DECISION DELEGATED TO HEAD OF PLANNING

Application No: H05-0861-25 **Applicant:** Mr A Wright
Proposal: Proposed Dwelling
Location: Adjacent To 14 Cross Street Fleet Spalding
Terminal Date: 10th November 2025

**PLANS, ELEVATIONS & SECTIONS
(Dwg 082202 PD201 D2)**

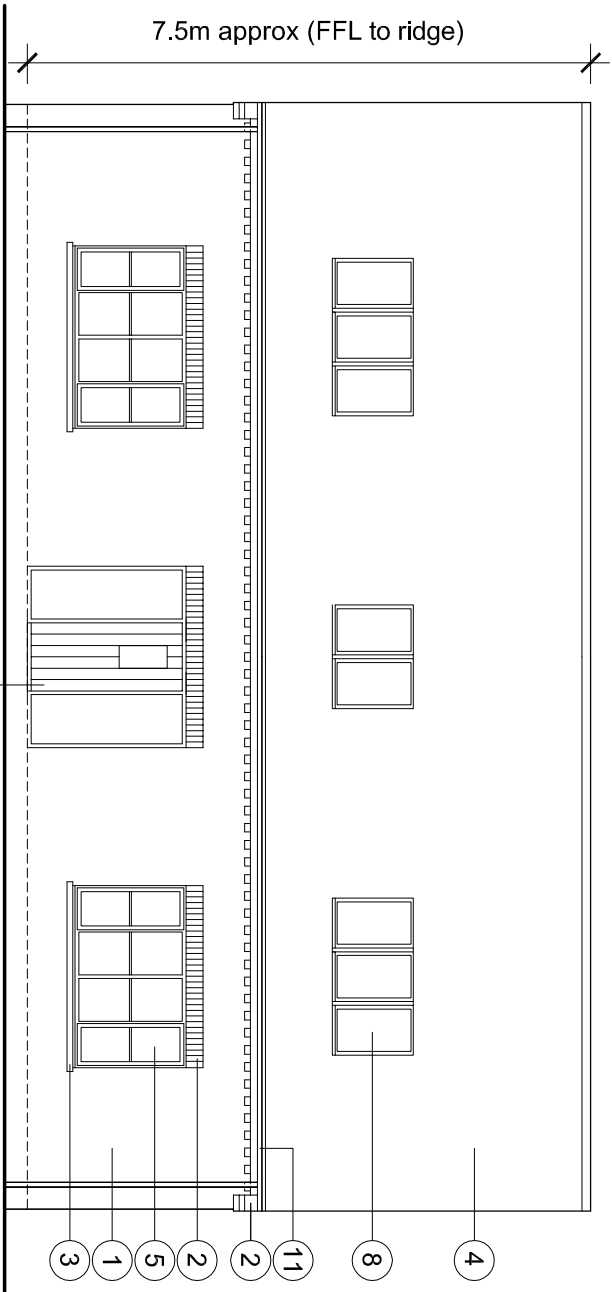
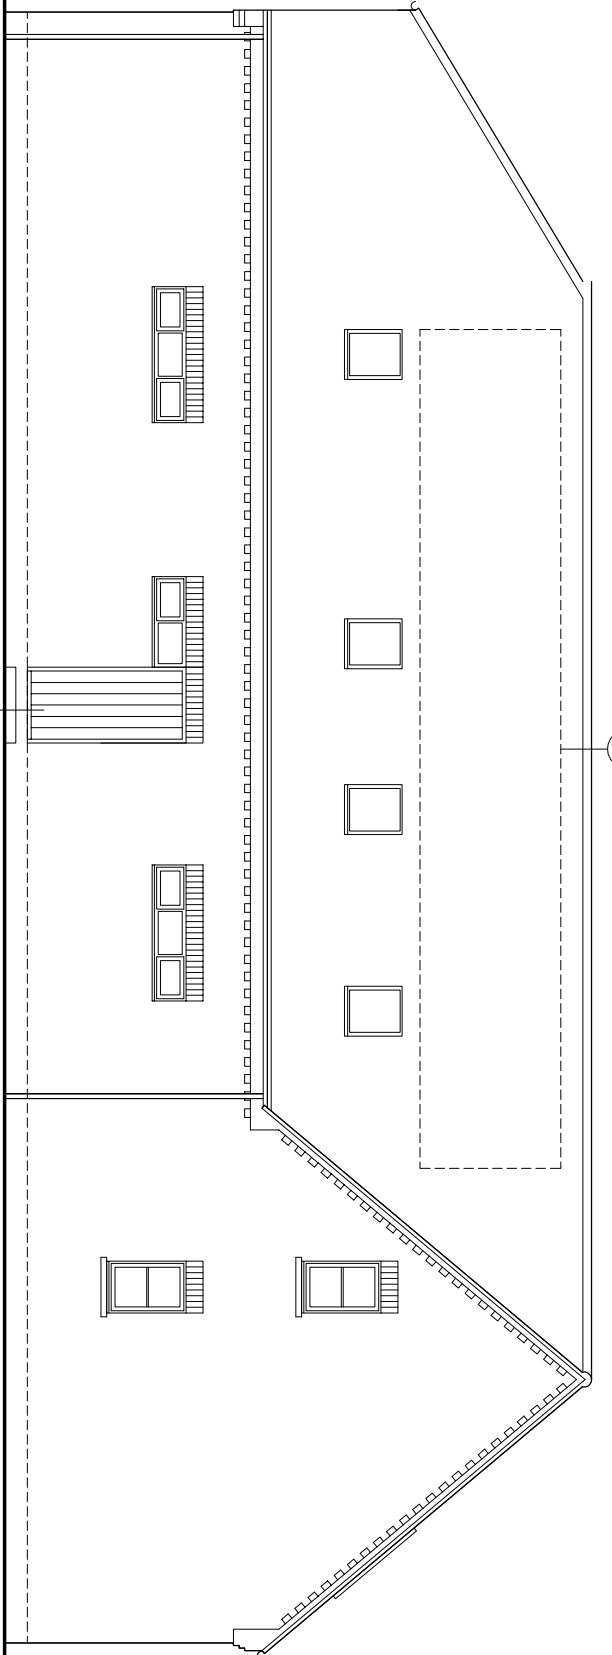
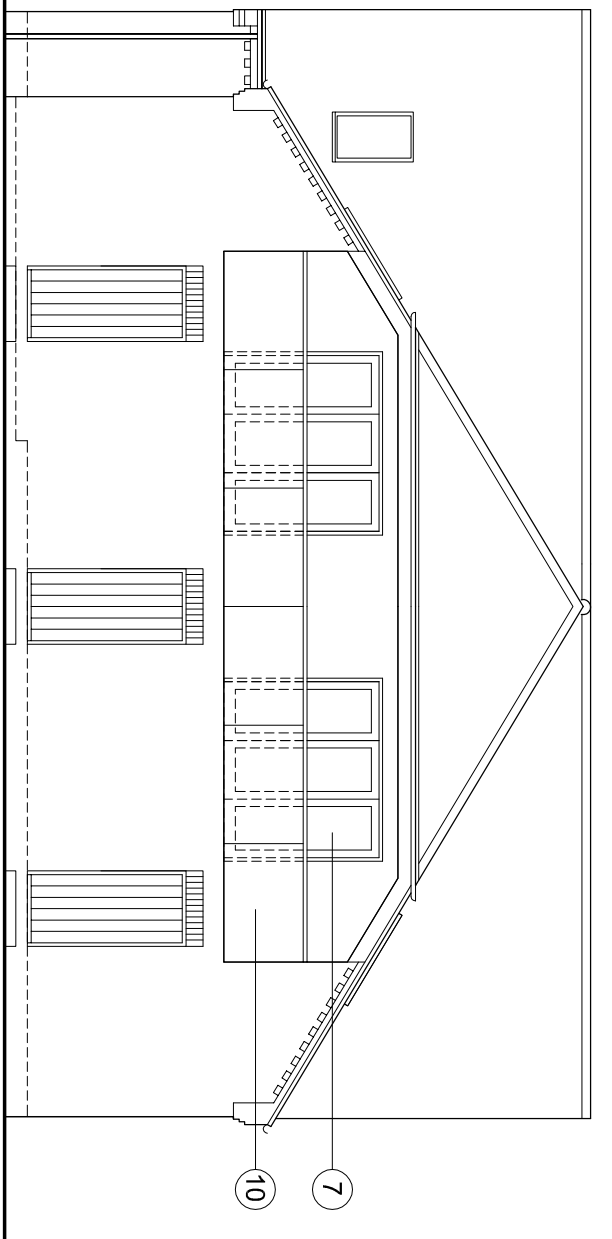
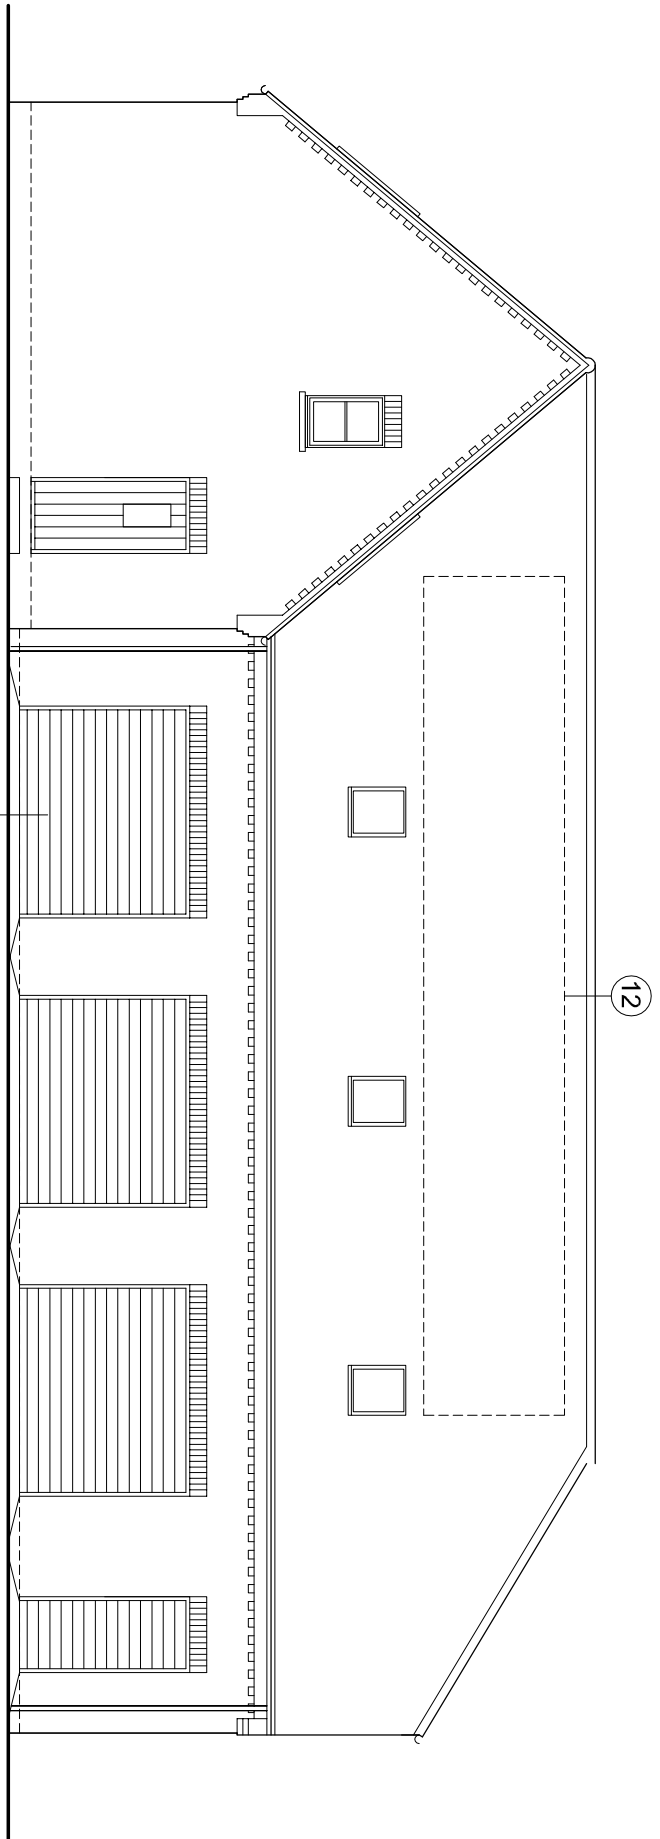
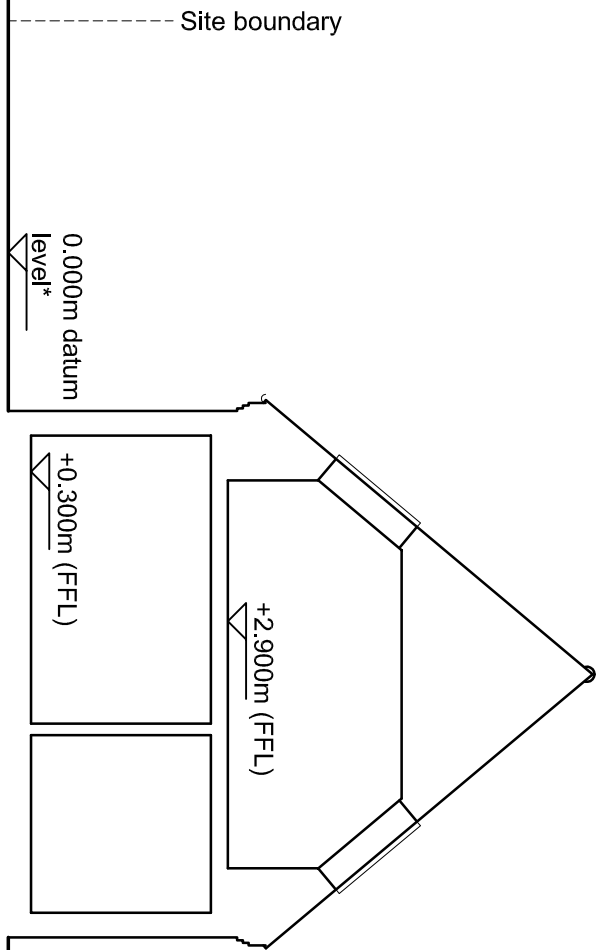
The proposed development in this instance seeks permission for a chalet style dwelling, comprising an approximate height of 7800mm (the submitted drawing specifies 7.5m from FFL to ridge, with the FFL being 0.3m above existing ground levels). The layout of the dwelling would create an internal floor space of 296.6sqm, across the ground and first floor.

Whilst the proposal is not necessarily two-storey, it does comprise a chalet design with a notable ridge height of 7.8m, which would not be uncommon for a standard two-storey dwelling.

The resultant development, comprising a height of 7800mm and proposing a chalet design, would result in the introduction of a built form that would be at conflict with this well established and consistent design pattern, particular along the southern side of Cross Street, which consists of modest scaled, and much lower, bungalows.

In this regard, the resultant height is significantly taller than the extant dwellings that neighbour the plot to the east and west. Firstly, No.14, to the west, has a total height of approximately 6000mm (taken from H05-1163-22); whilst No.18, to the east, has an approximate height of 5500mm (taken from H05-0800-99). This further demonstrates that the proposed dwelling is unsuitable and fails to take account of the prevailing nature and scale of development within its immediate vicinity, being at least 1700mm taller than its direct neighbour, and around 2200mm taller in the more extreme circumstance.

This letter also goes on to say that the *'Scale and form reflects that of a single storey dwelling with room-in-the roof accommodation'*. The LPA strongly disagree with this claim. The height of the proposed development is more akin to that of a standard two-storey dwelling, being 7.8m in height. The neighbouring bungalows have heights of 6.0m and 5.5m respectively and as such, when specifically referring to the bungalows pertinent to the immediate vicinity of this site, the proposed dwelling is vastly in excess.

First Floor Plan (1:100)

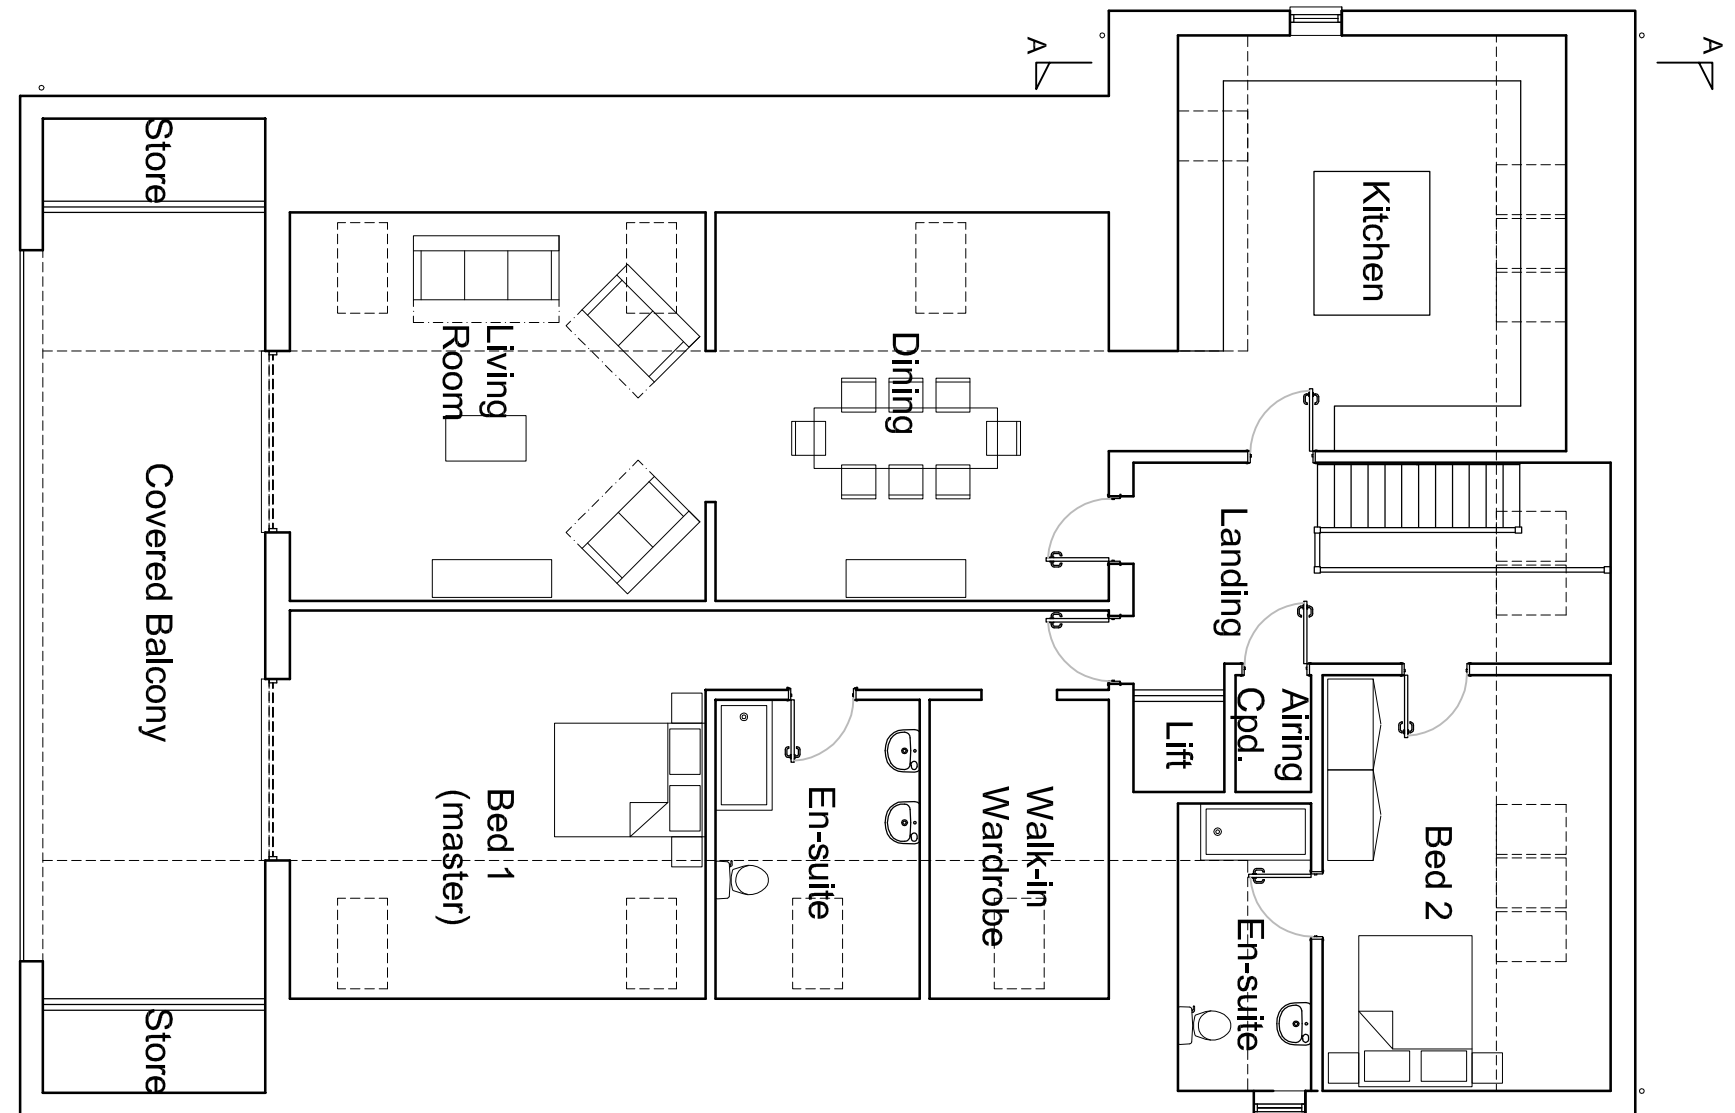
In regard to overlooking, there is potential for impact to be caused through the siting of the living room on the first floor, with windows in the roof facing towards No. 14. Notwithstanding that these are rooflights, when viewed from the eaves to the top of the window on the west elevation, there is only a height of 1700mm; with this lessening towards to foot of the window. This is a similar arrangement for those located within Bedroom 1 on the east elevation as this features the same window design, with future residents in this room having the ability to overlook into No. 18 rear garden and result in a loss of privacy to an unacceptable level.

As a result, the future occupiers of the dwelling would have fairly easy and accessible views from the first floor towards this neighbouring properties rear garden and side windows; which would not typically be associated with rooflights, given there usual high level siting. As a result, this would cause an unacceptable level of overlooking and therefore harmful loss of privacy.

Roof Plan (1:100)

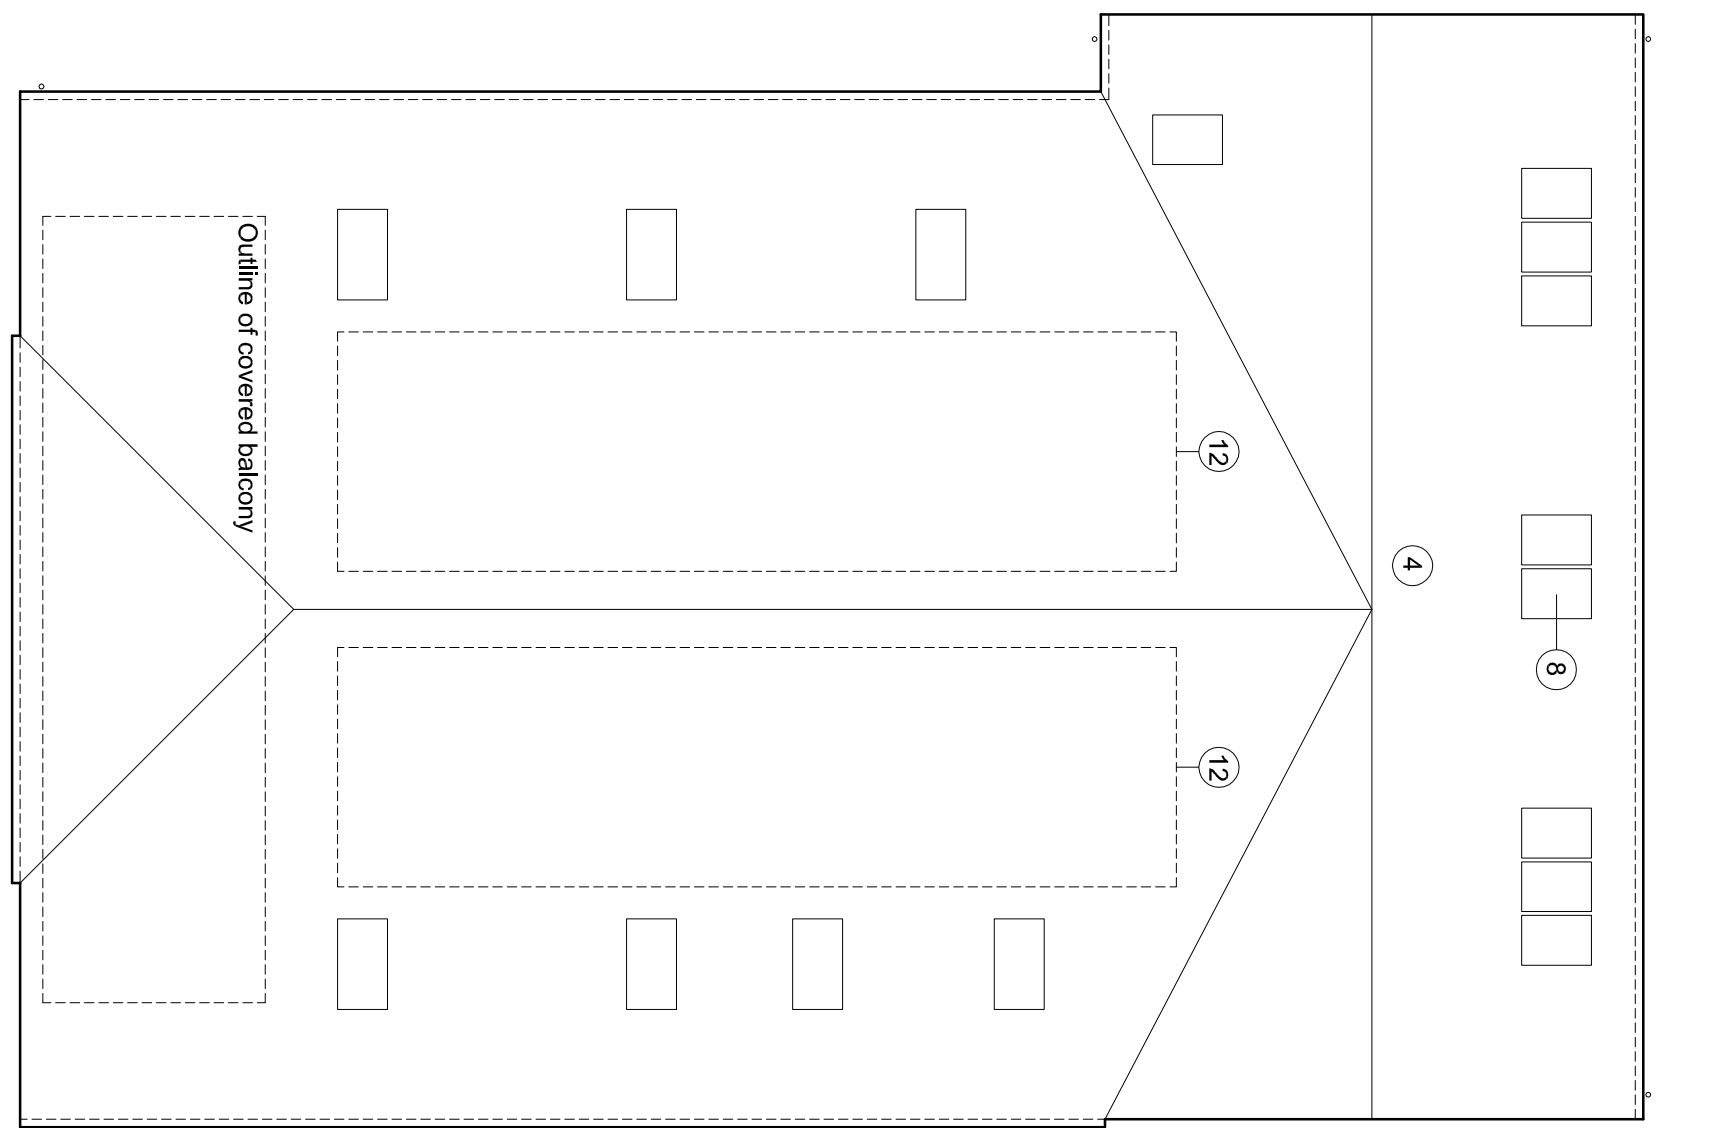
The proposal is such that the overall scale of the proposed dwelling, in respect of its mass, bulk and height; coupled with the location of roof windows and there low level within the roof slope on the east and west elevations, would cause opportunities for a material loss of privacy to No. 14 and No. 18 Cross Street, whilst causing an overbearing and unacceptable impact.

The overall scale of the proposed dwelling, in respect of its mass, bulk and height; coupled with the location of roof windows and there low level within the roof slope on the east and west elevations, are considered to cause opportunities for a material loss of privacy to No. 14 and No. 18 Cross Street, whilst causing an overbearing and unacceptable impact.
